# SITE DEVELOPMENT PLANS FOR SUPER STAR CAR WASH FALCON MARKETPLACE LOT 10

PCD FILING NO.:  
PPR-21-008

REVISIONS		DATE
REVISION	DESCRIPTION	
1	SSCW - FALCON MARKETPLACE - 2ND SDP SUBMITTAL	07/15/2021
2	SSCW - FALCON MARKETPLACE - 3RD SDP SUBMITTAL	08/13/2021

COLORADO  
EL PASO COUNTY  
COVER  
SUPER STAR CAR WASH - FALCON MARKETPLACE LOT 10  
SITE DEVELOPMENT PLAN

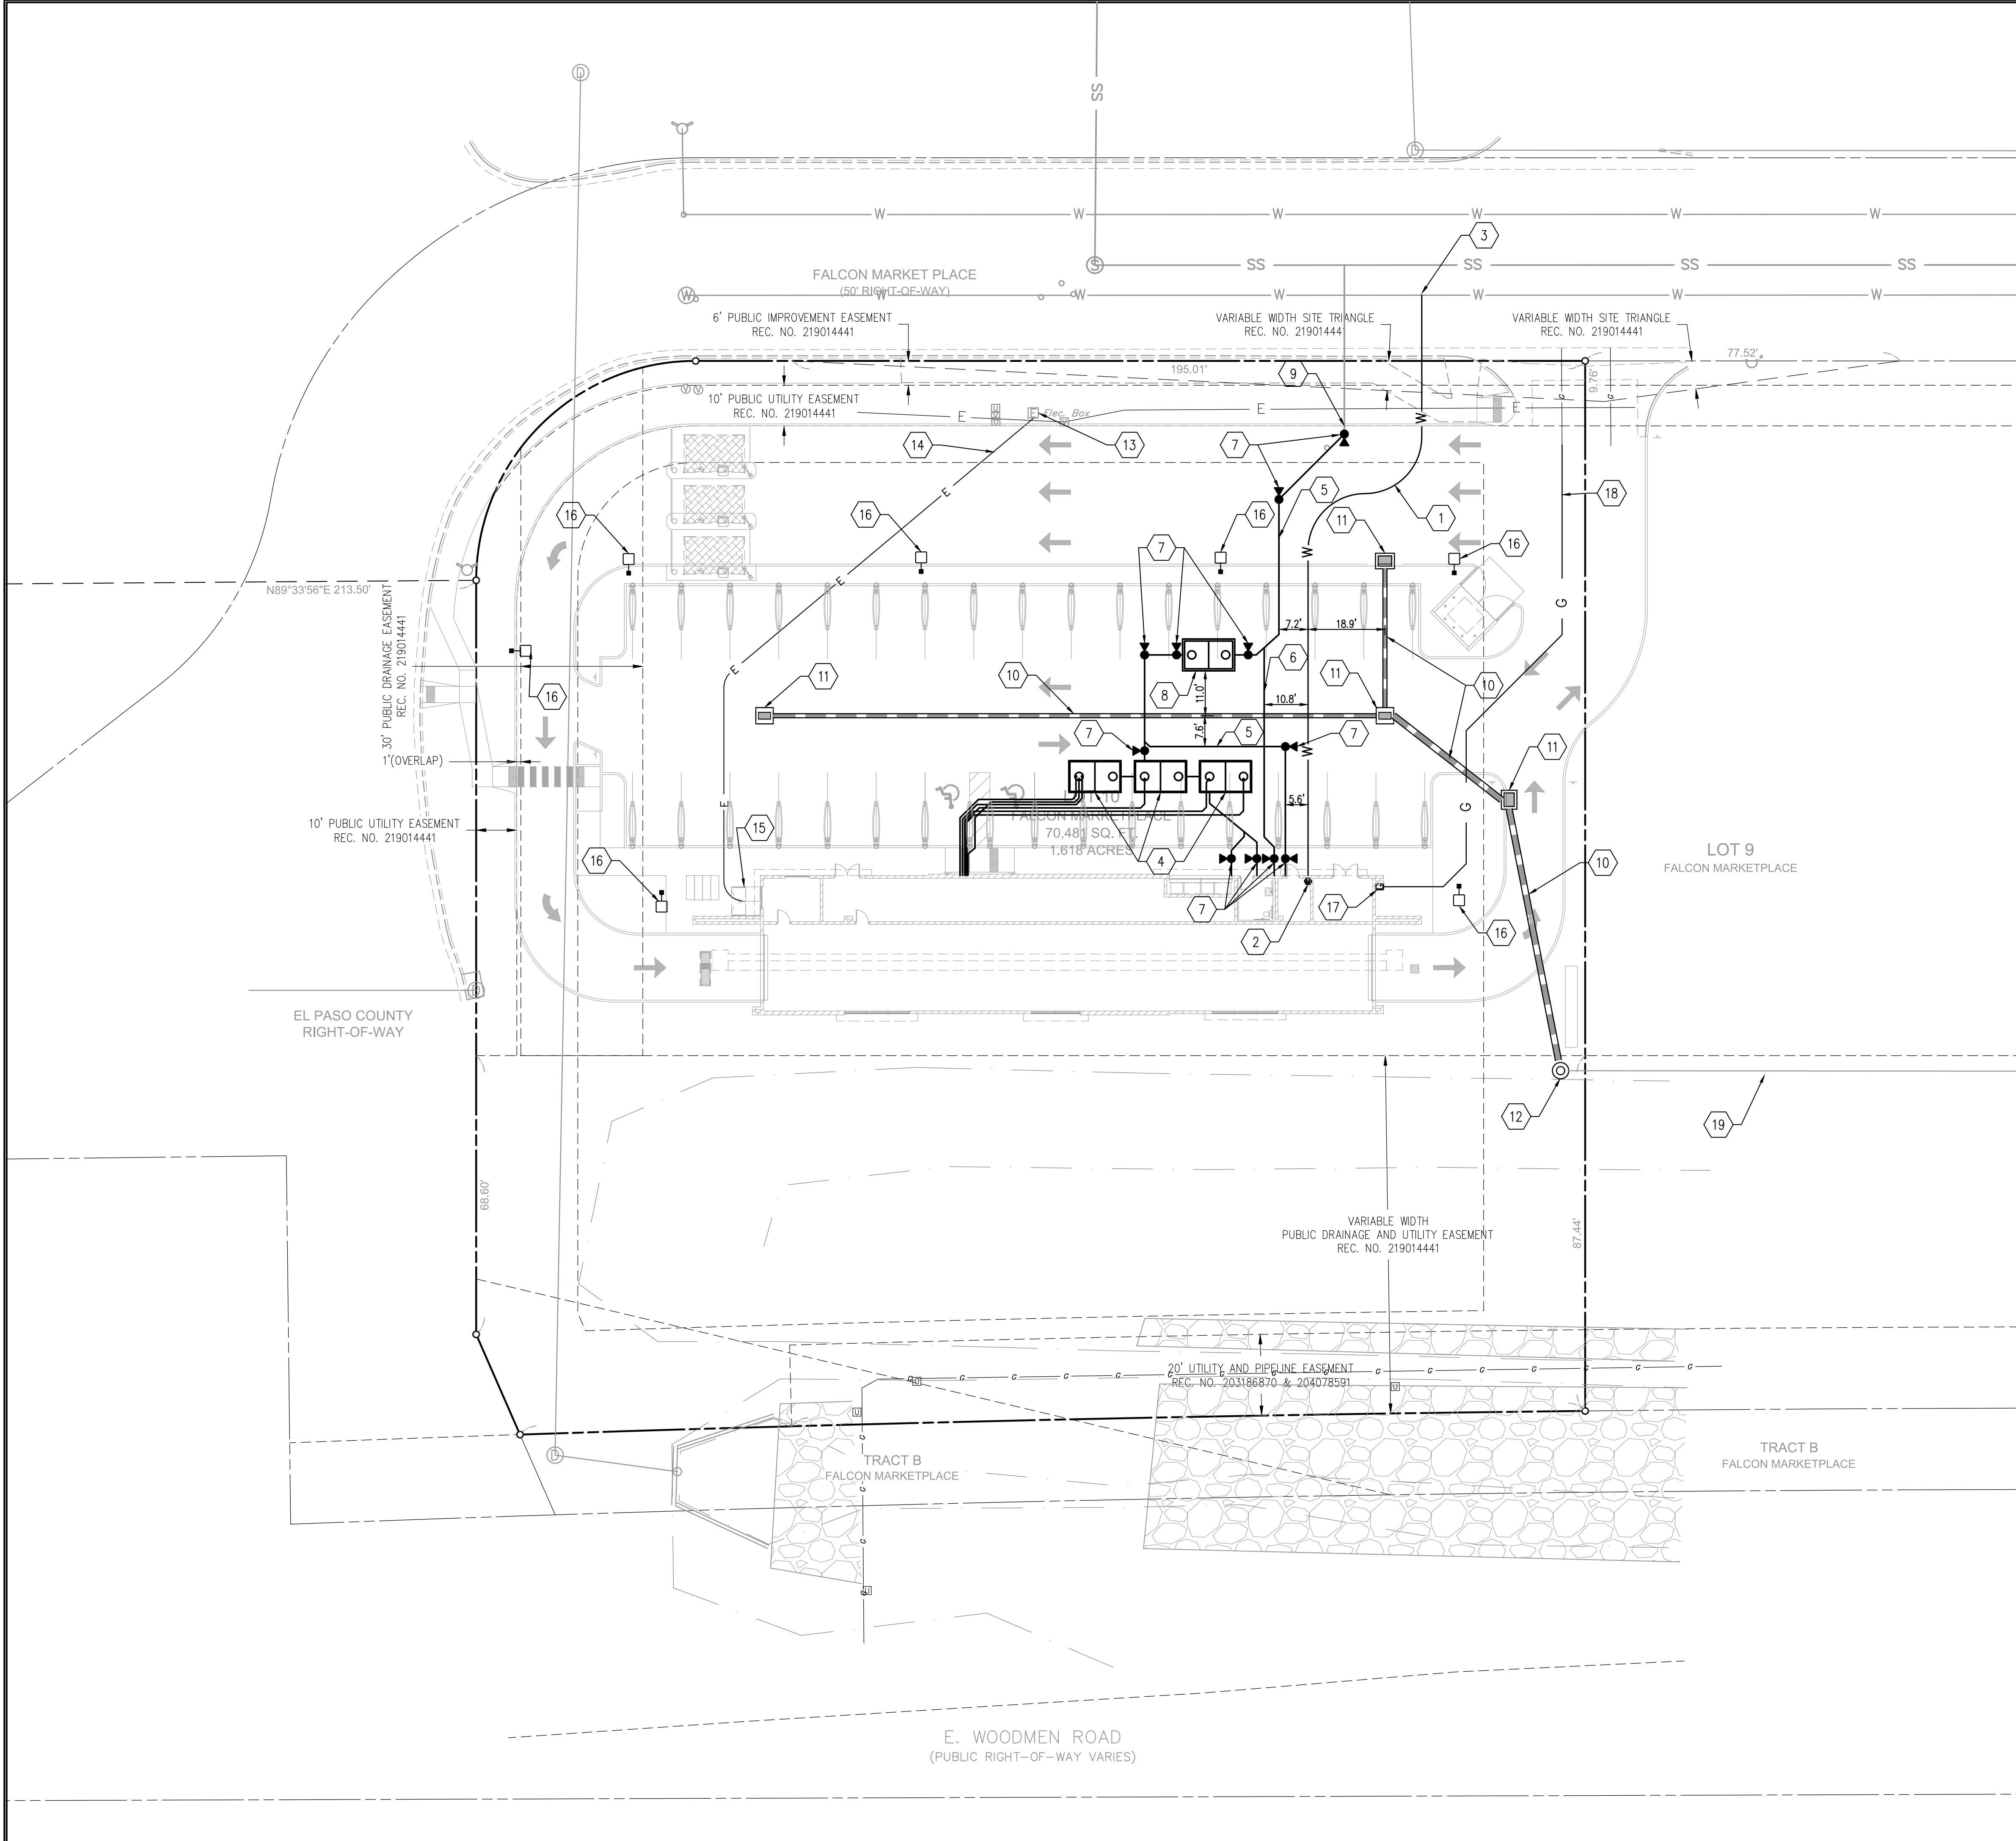
Please add the following ADA note:

GENERAL COMMENT THROUGHOUT : Please remove all separate plan sets from this plan set and include in the appropriate plan sets. You are including lighting, landscaping, grading, and stormwater pages that do not need to be included in this set.

Please replace signature block with a signature block for the Planning and Community Development Department Director.

The parties responsible for this plan have familiarized themselves with all current accessibility criteria and specifications and the proposed plan reflects all site elements required by the applicable ADA design standards and guidelines as published by the United States Department of Justice. Approval of this plan by El Paso County does not assure compliance with the ADA or any regulations or guidelines enacted or promulgated under or with respect to such laws.
